Our Ref: 09-374 GC:BL
Your Ref: DA09/0701.03 LN 35979

26 July 2018

Altitude Aspire Estate
MP09/0166 MOD 3
(Council Ref DA09/0701.3)
RFI Response to letter 11 May 2018

SK3618/3
REVISION H

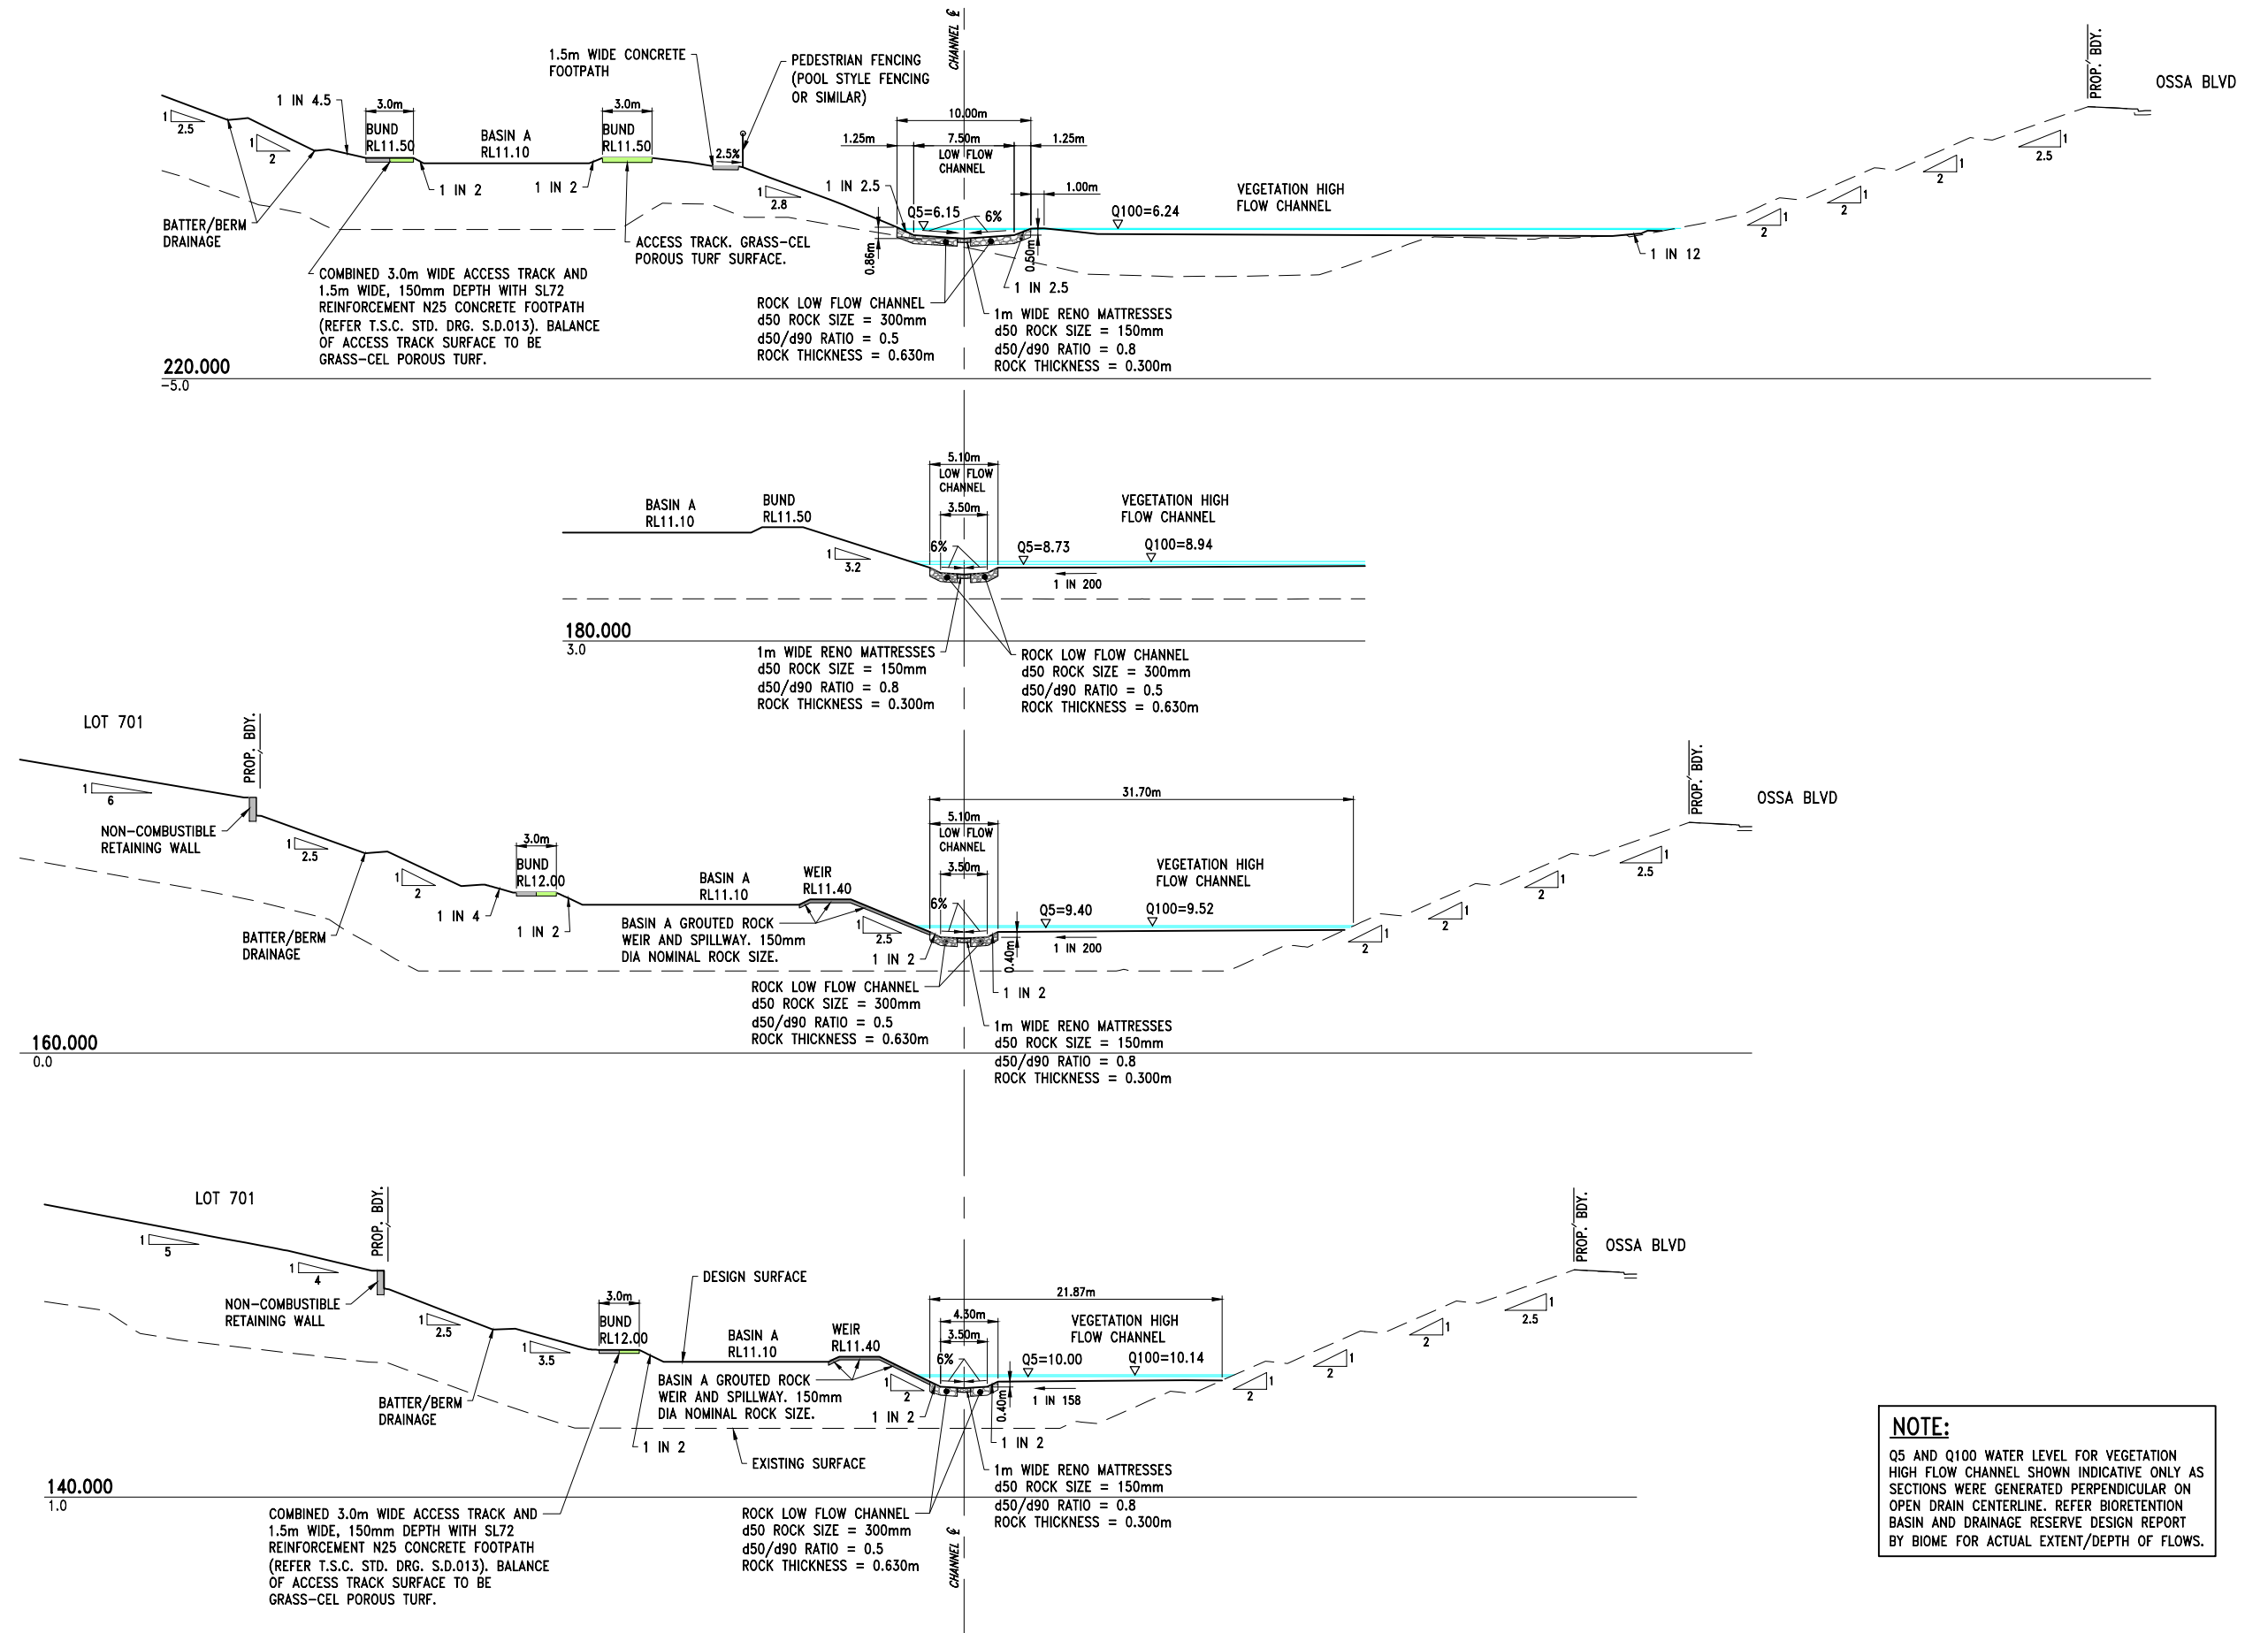
- e) Maintenance accessibility is provided with 3m wide access tracks as shown on drawing SK3618 sheets 1, 2 and 3. The access tracks enter off Broadwater Parkway and provide direct access for maintenance to each of the bio basins.

The Maintenance Access tracks also provide access to the central drainage channel at strategic locations for maintenance, with the provision of "turn-a-round" areas for small maintenance vehicles, at which point it is envisaged maintenance will be carried out "on foot".

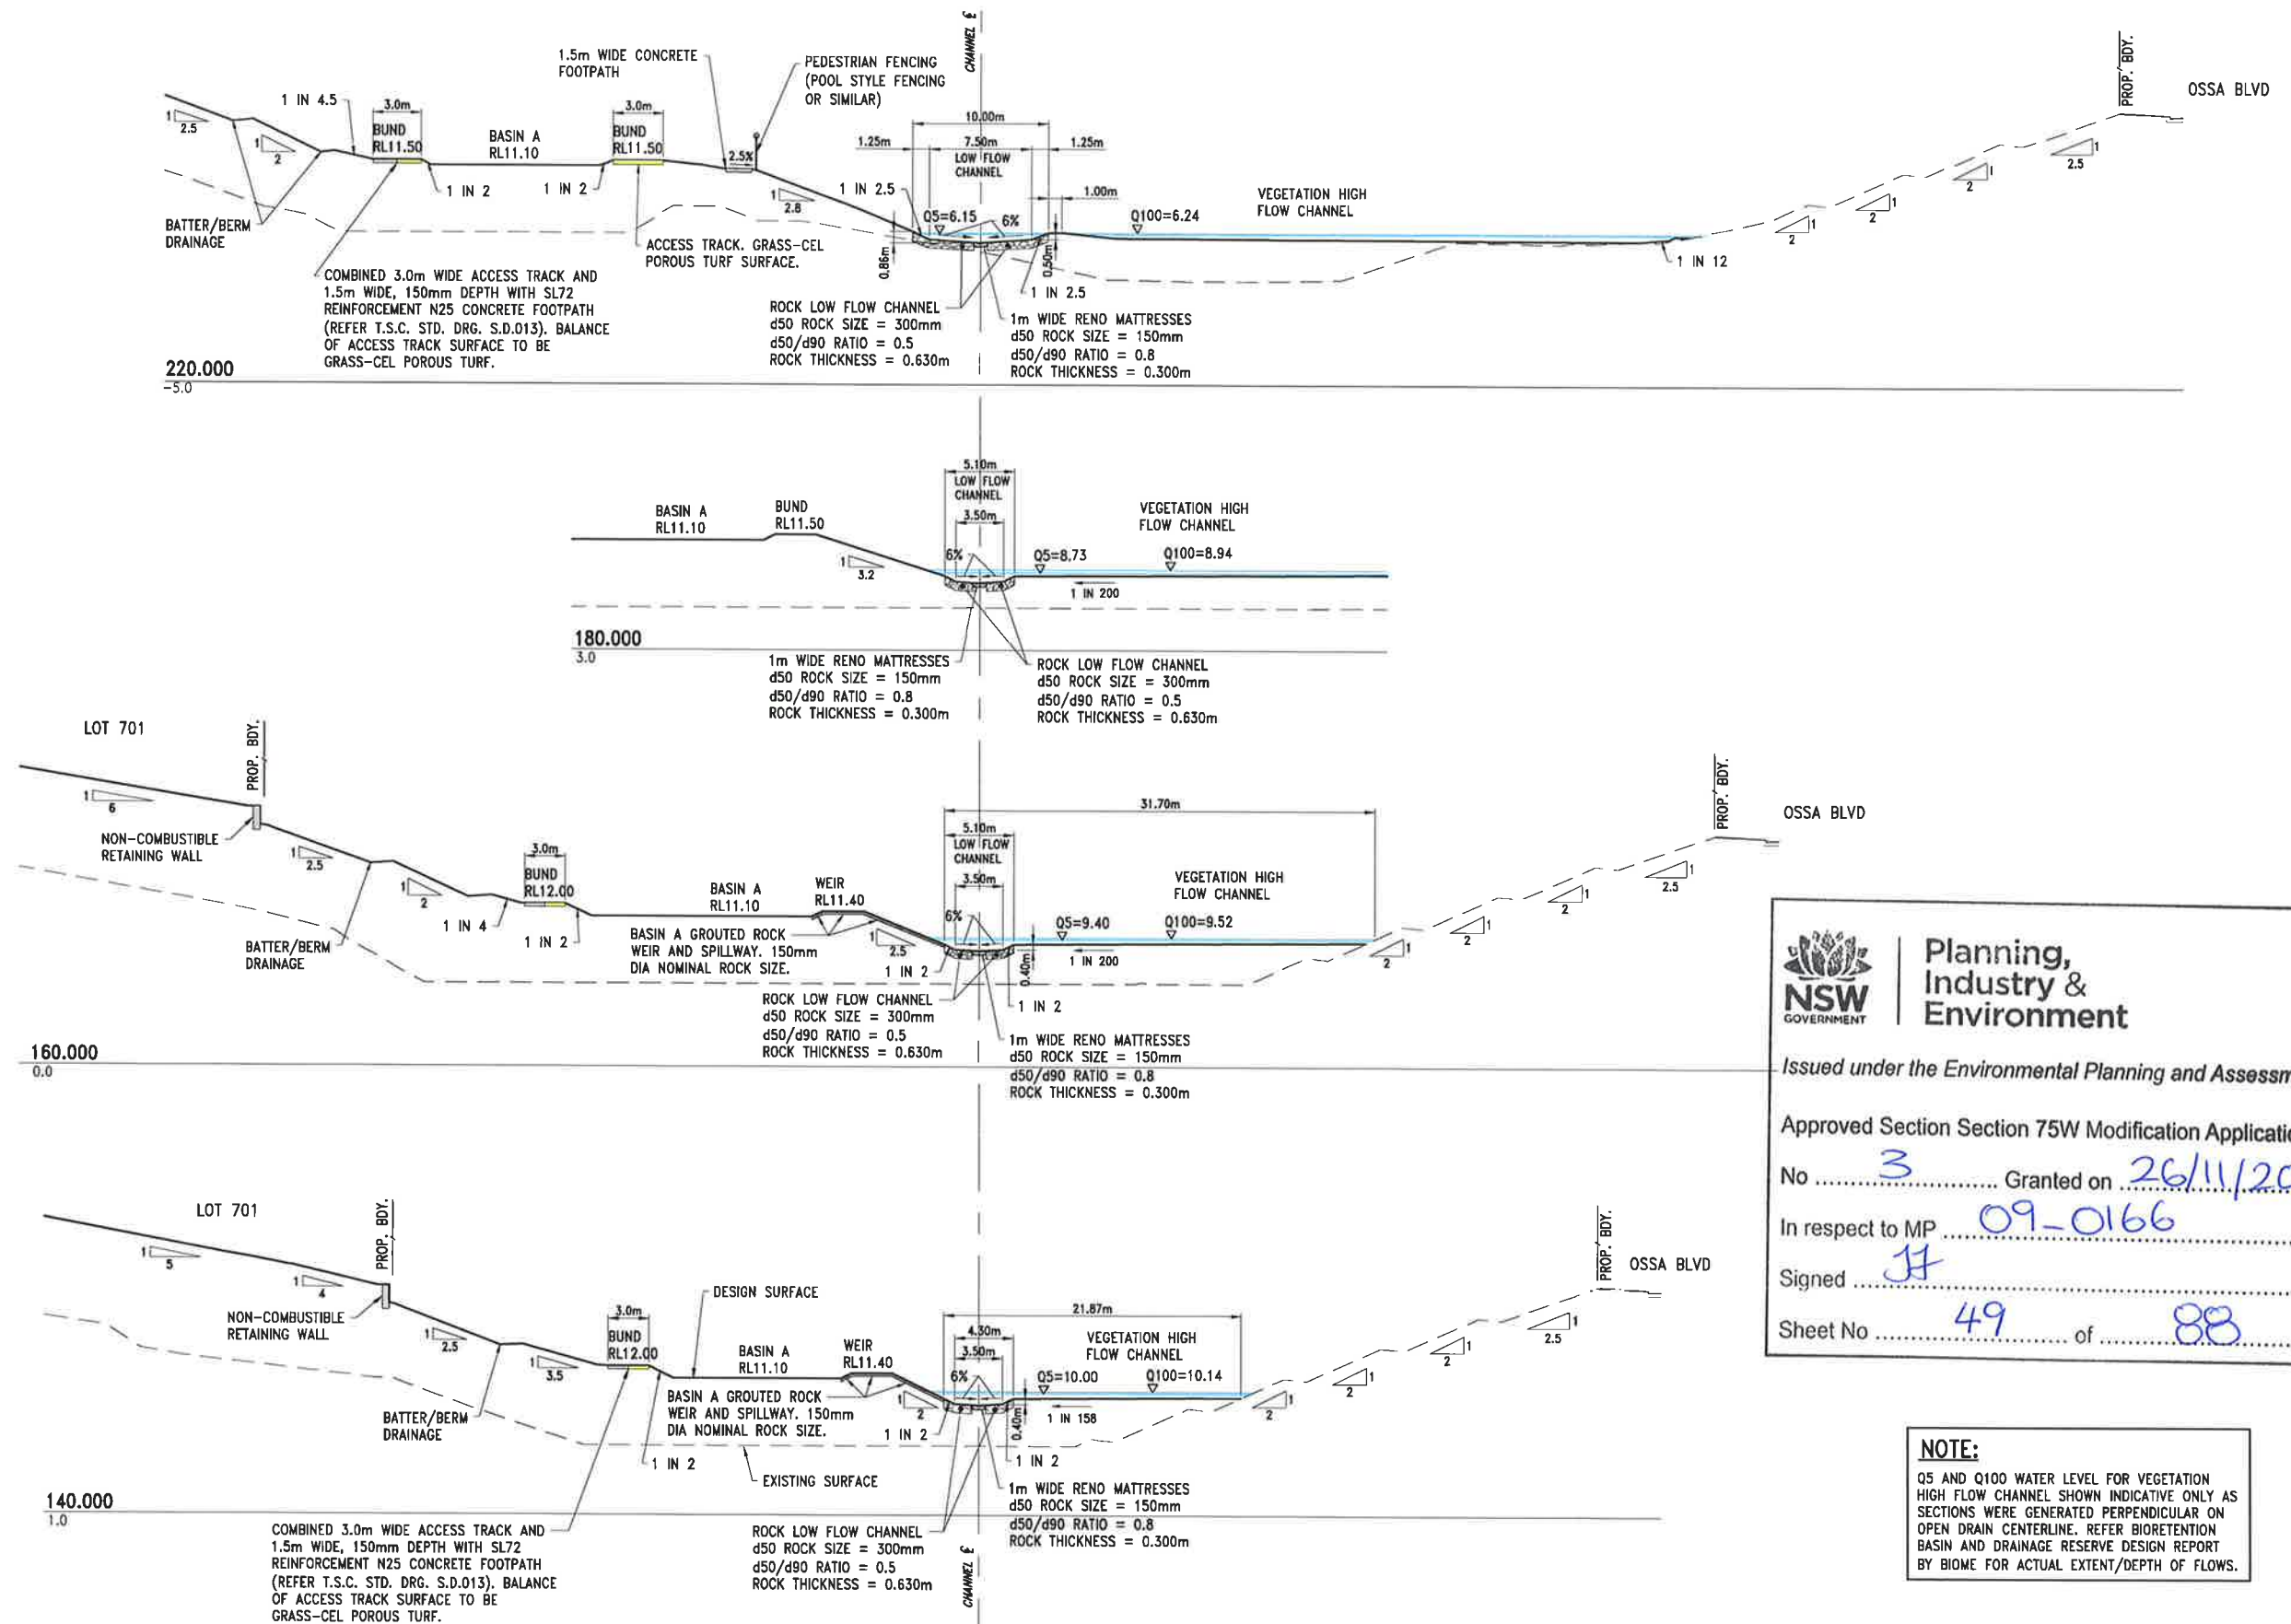
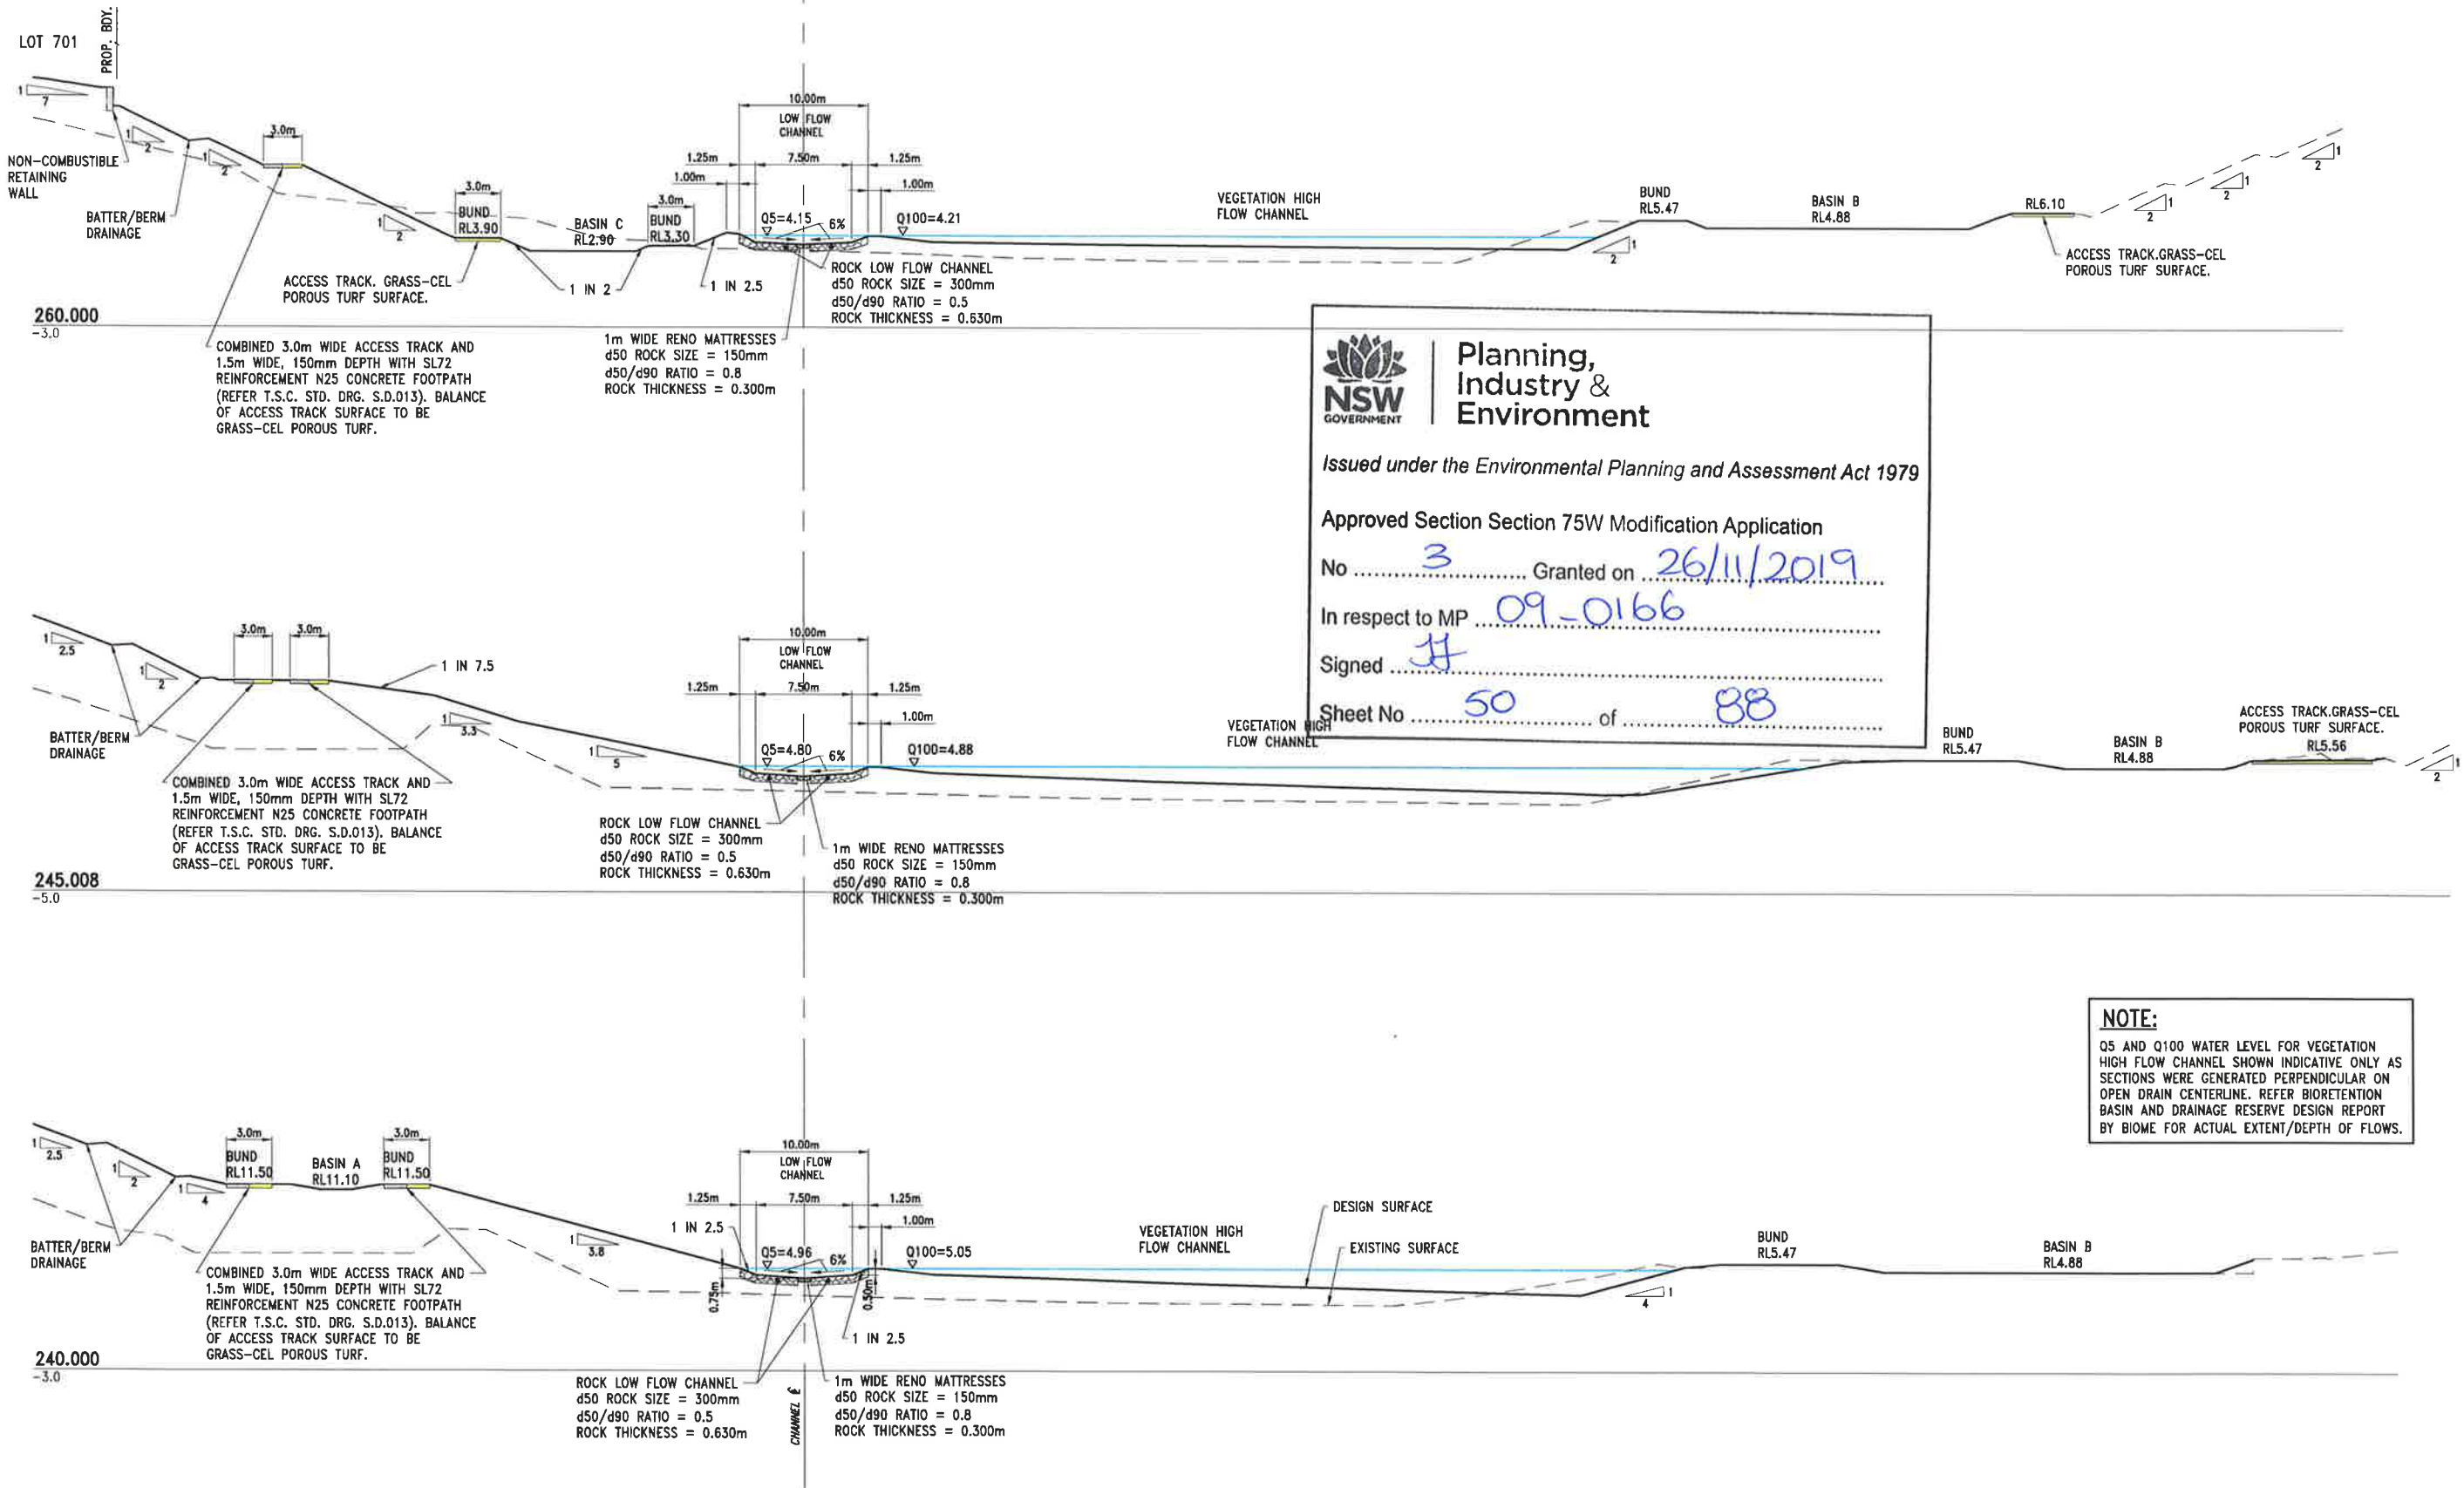
- c) Batter slope variability has been amended to reflect more closely Council concerns – refer long section drawing SK3619 Rev D and cross section drawings SK3620 Rev E to SK3625 Rev E inclusive.

- a) All batters within the Central Drainage Corridor have been revised so that no batter is steeper than 1 on 2. To protect against scour, all batters have been protected with rock rip-rap to the height of the expected 100-year ARI plus 300mm freeboard. Please refer to BIOME report also attached.

- d) Treatment of all batter slopes steeper than 1 on 4 have been detailed in FORM landscape drawings. To protect against scour, all batters at 1 on 2 within the drainage conveyance channel are to be treated, with rock rip-rap up to a height of the expected 100-year ARI plus 300mm freeboard.
